06/07/2009

Re: Lot 9 and Lot 358 Morisset Park Road, Morisset Park – Response to Council's Stormwater Queries

We provide the following information to address Lake Macquarie City Council's (LMCC) concerns raised in their letter dated 21.05.09. The information provided has taken into account:

FIGURE 2- Post Development catchment plan

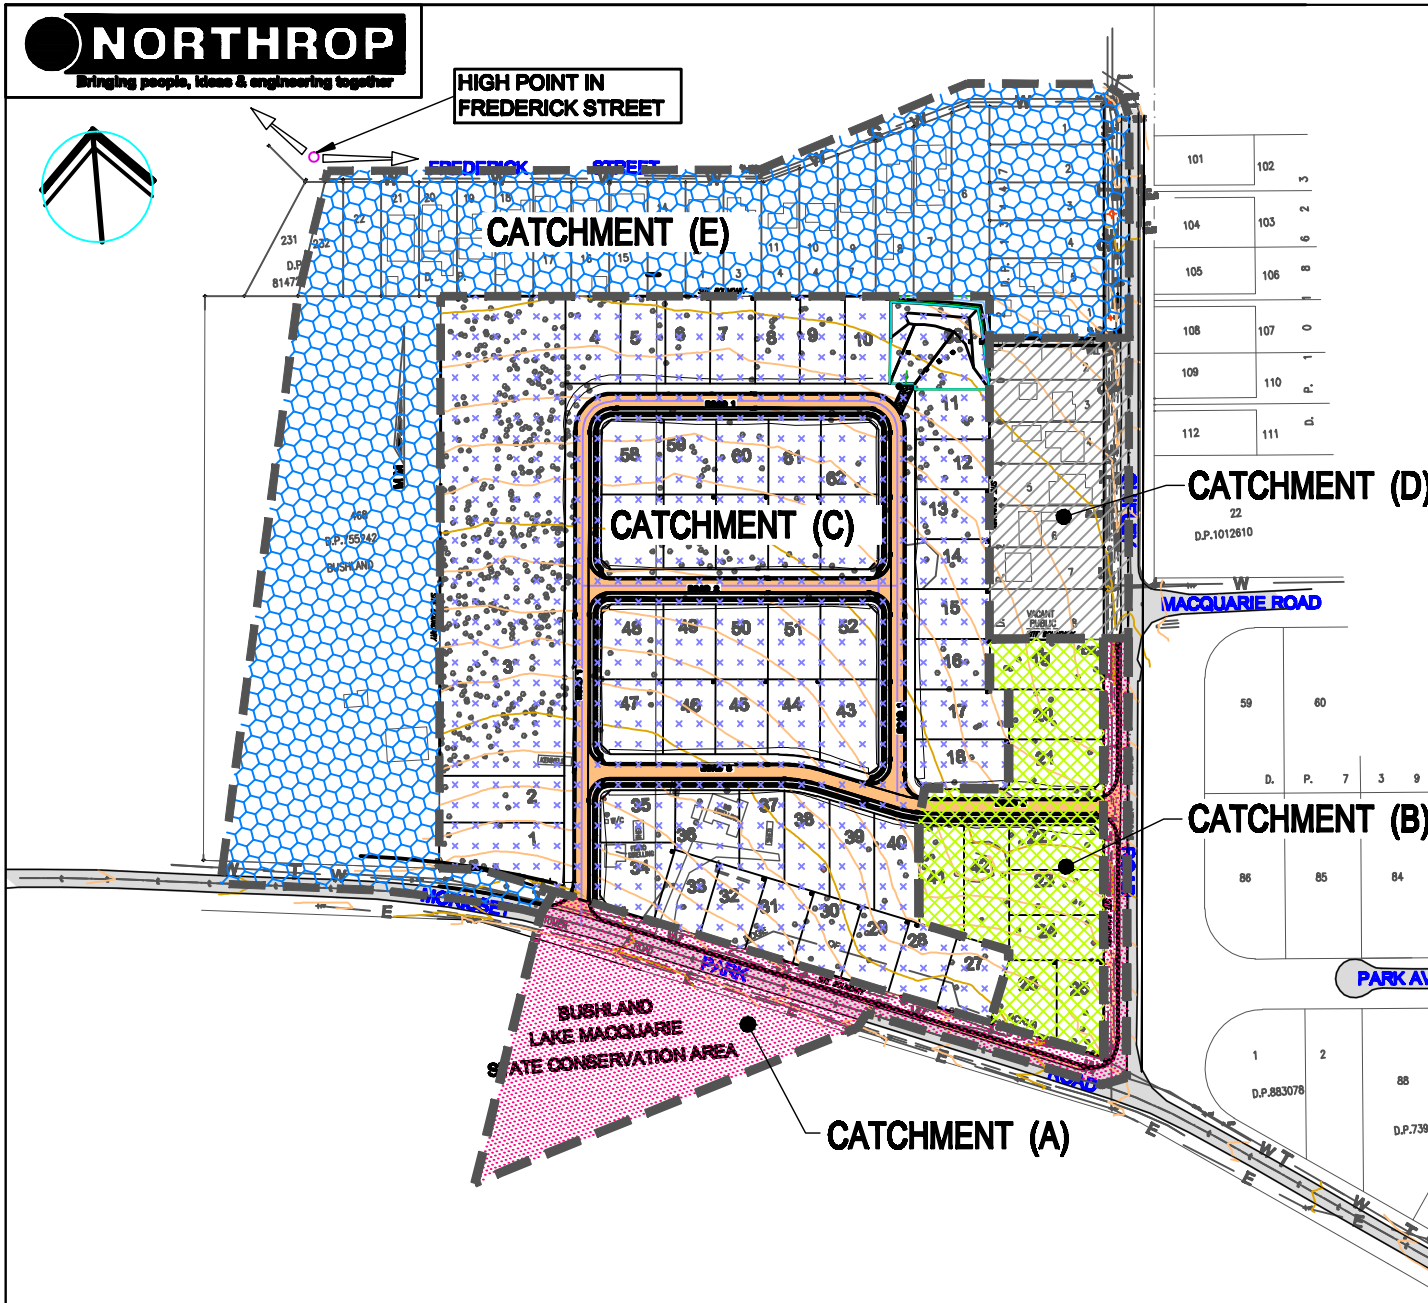
Further to discussions with Council, we have now modeled the wider catchment which contains the site. Figure 1 and Figure 2 (Attachment 1) illustrate the Pre-developed sub-catchments and Post Developed sub-catchments respectively.

- Runoff from Sub-catchment B (refer Figure 2) will be treated via pit filter inserts (Watercycle Enviropits or similar) placed in new road stormwater pits. Sub-catchment B accounts for approximately 13% of the total site.
- Runoff from Sub-catchment A (refer Figure 2) will be treated by a two stage approach:

STORMWATER DETENTION BASIN PLAN

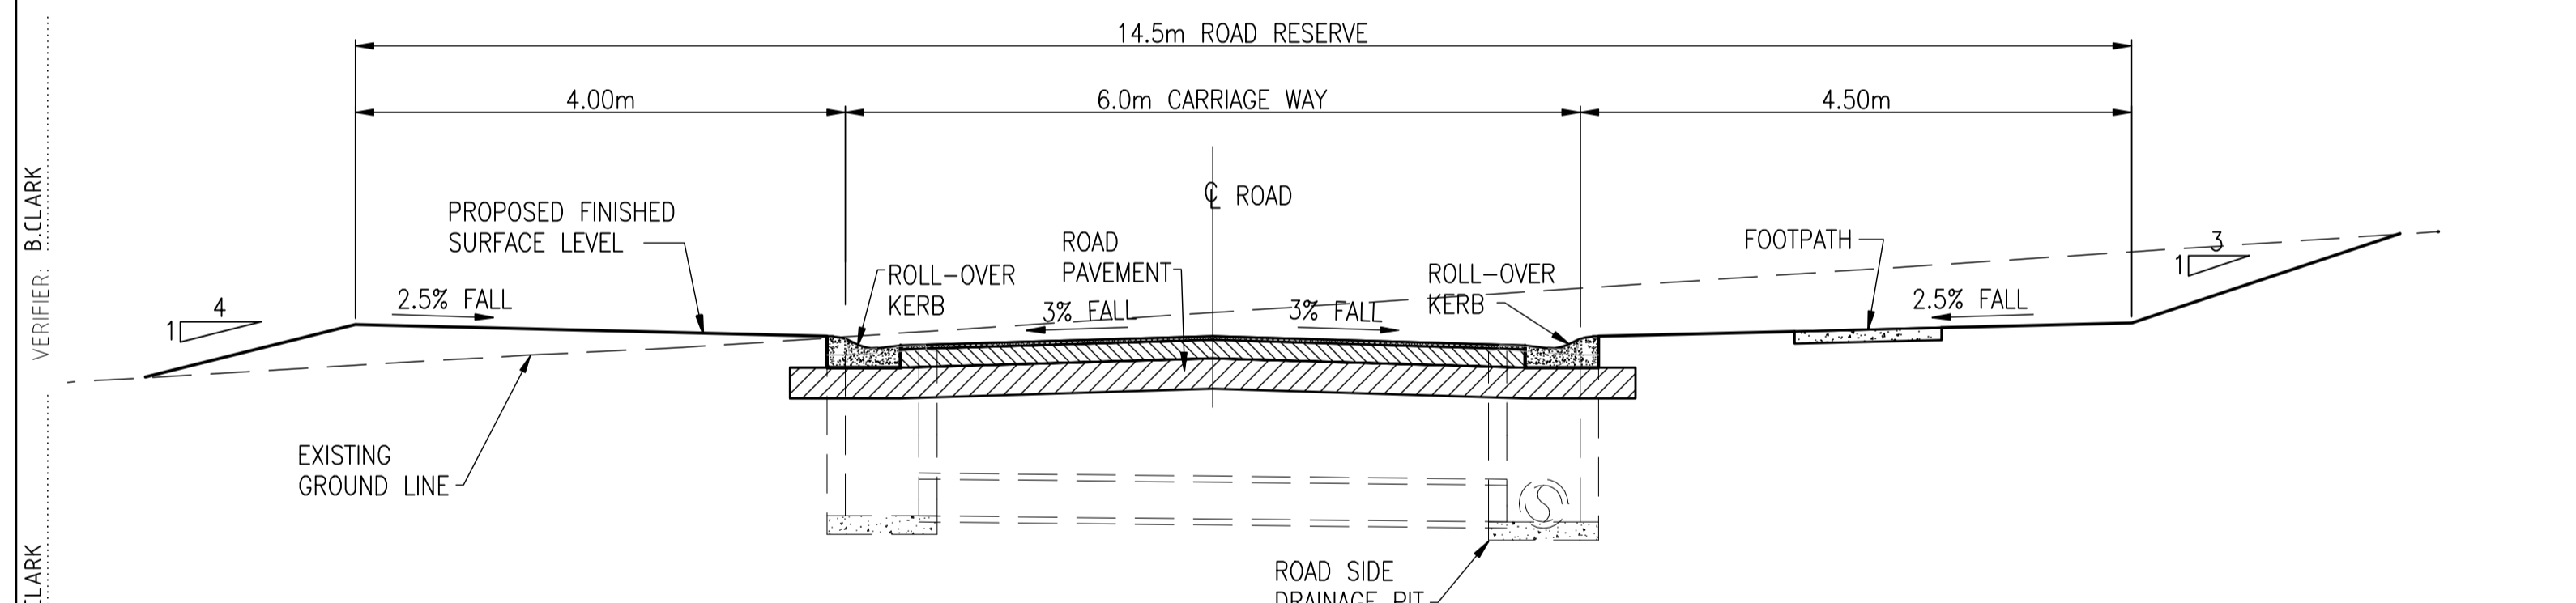
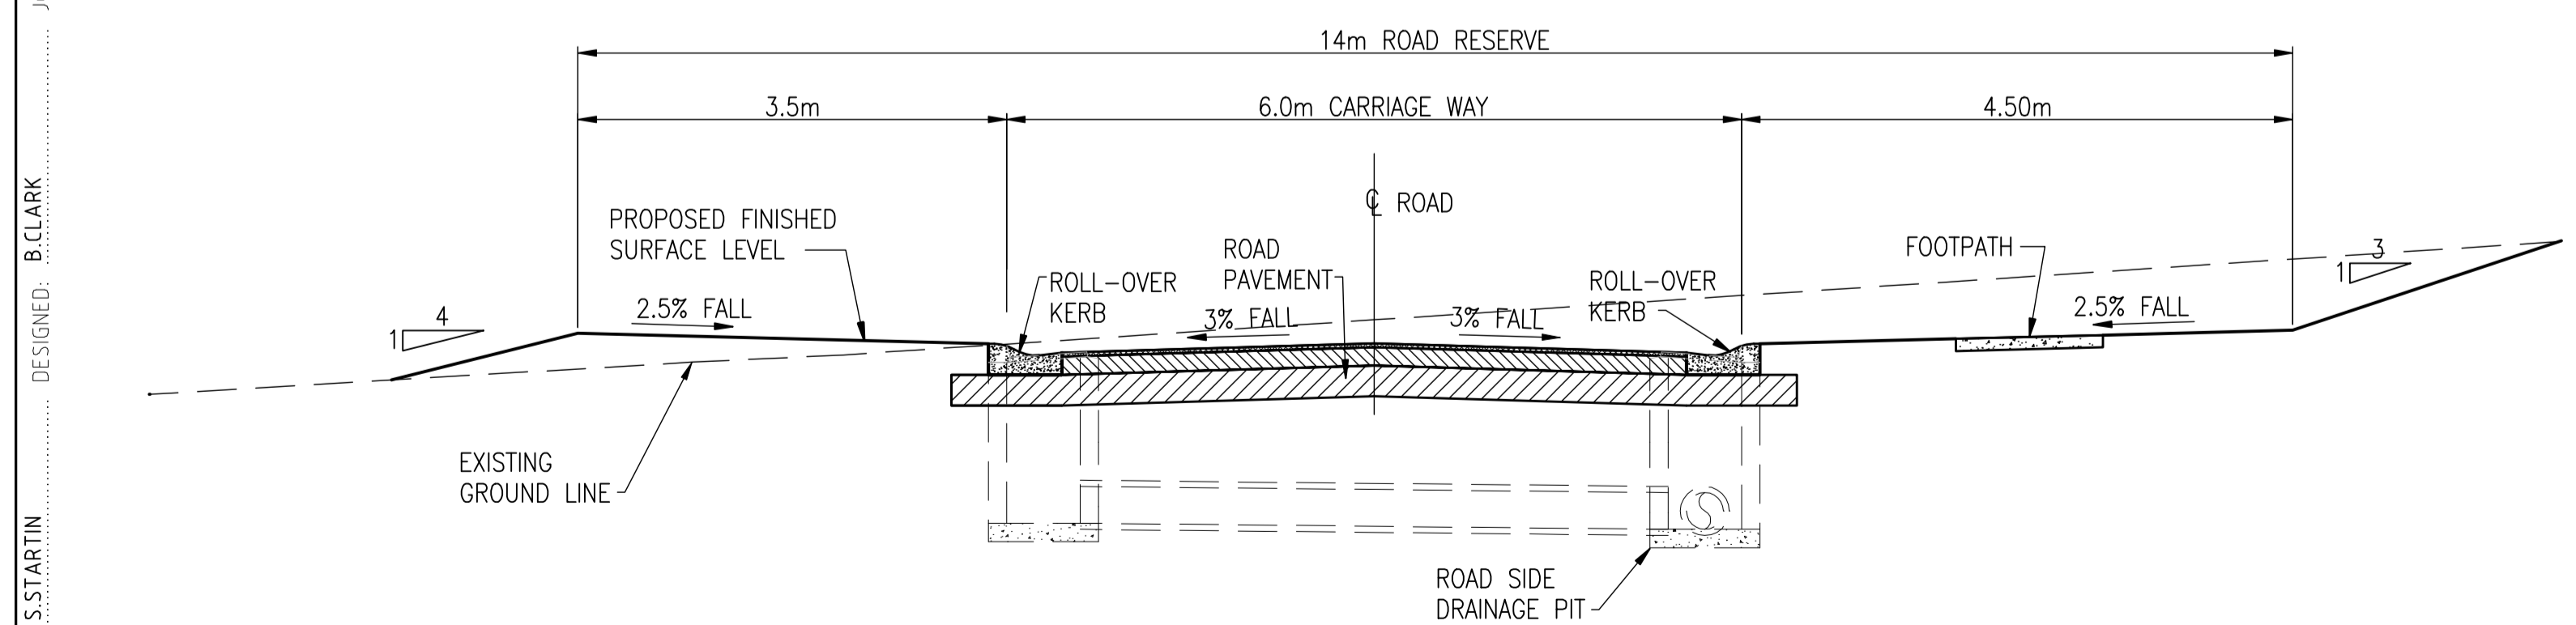
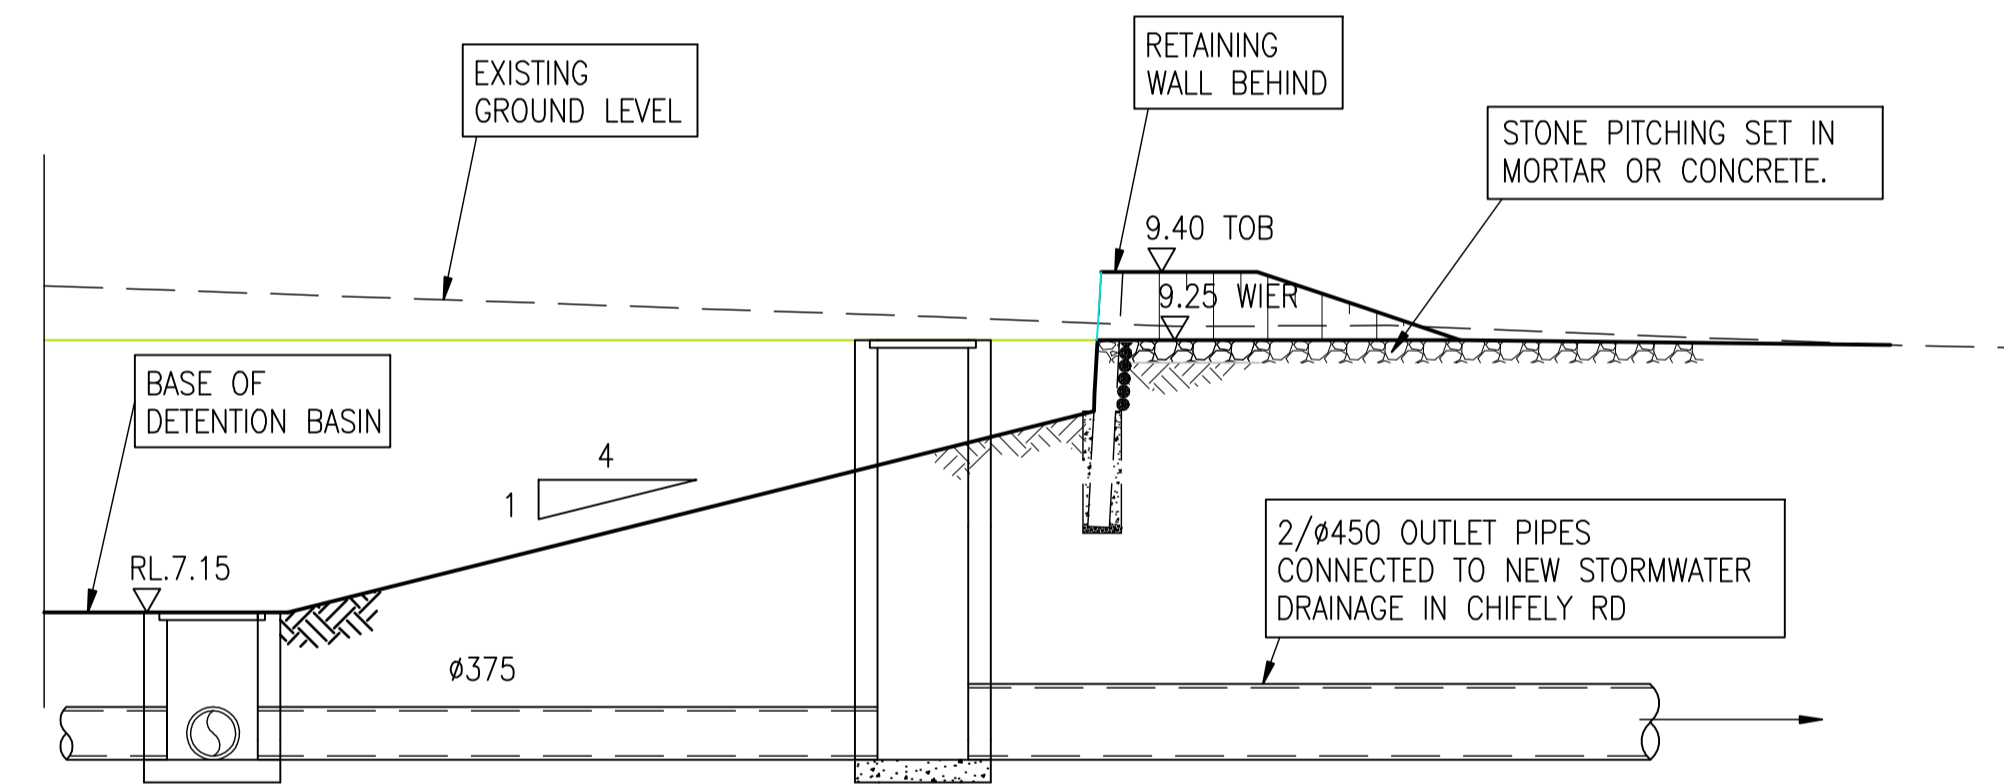
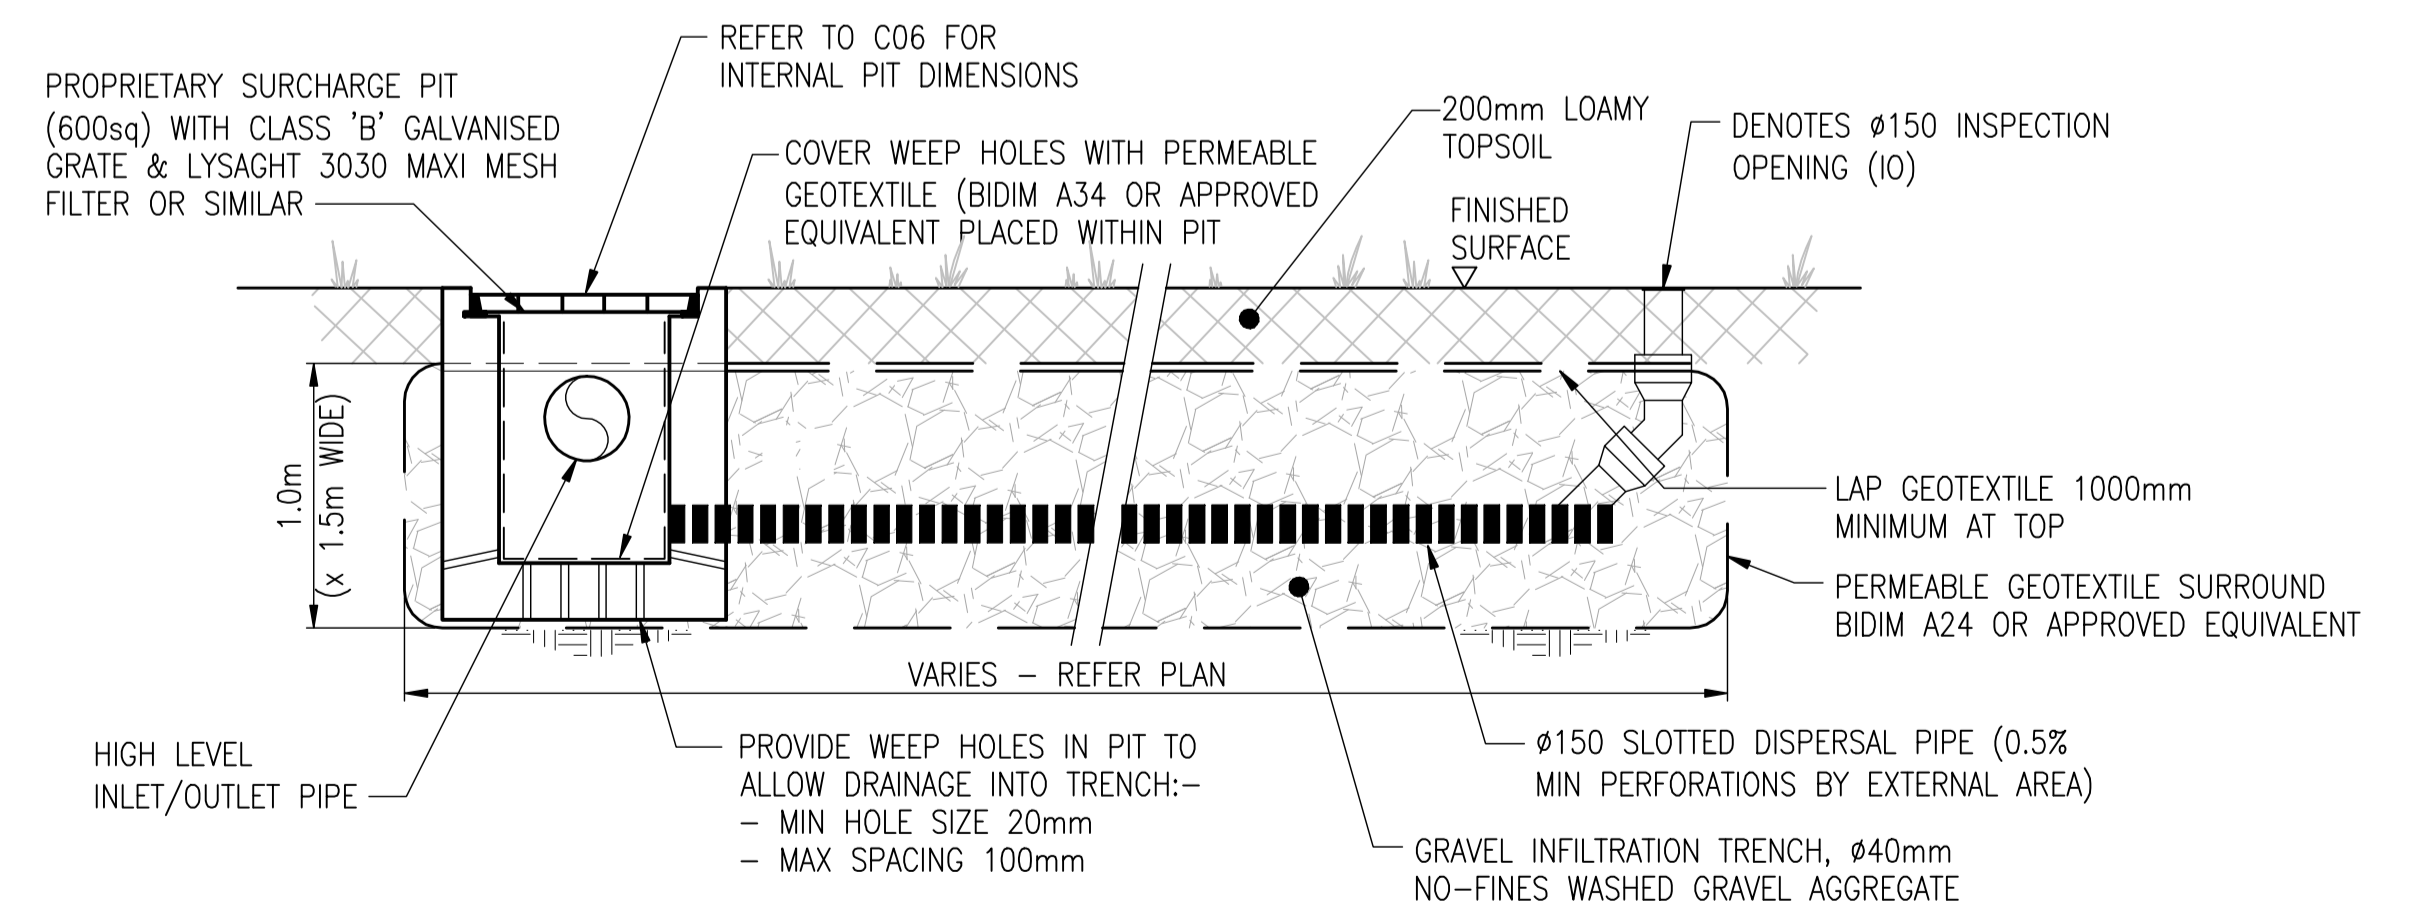
1. A Gross Pollutant Trap (GPT) will clean runoff of gross and coarse particles and sediment; and
2. A series of gravel trenches aligned with the contours of the 1:6H embankment of the Detention Basin (refer C03_DA Attachment 2). The gravel trenches will be designed to filter the runoff of fine sediments and attached nutrients as well as encourage infiltration into the insitu soils. In the event that the trenches overflow, runoff will then be further polished by the grassed embankment of the Basin.

Trenches shown in attachment 2 have a total storage volume for runoff of 42cu.m. This volume equates to 0.7mm and 6mm of runoff from Sub-catchment C and the road surfaces respectively.
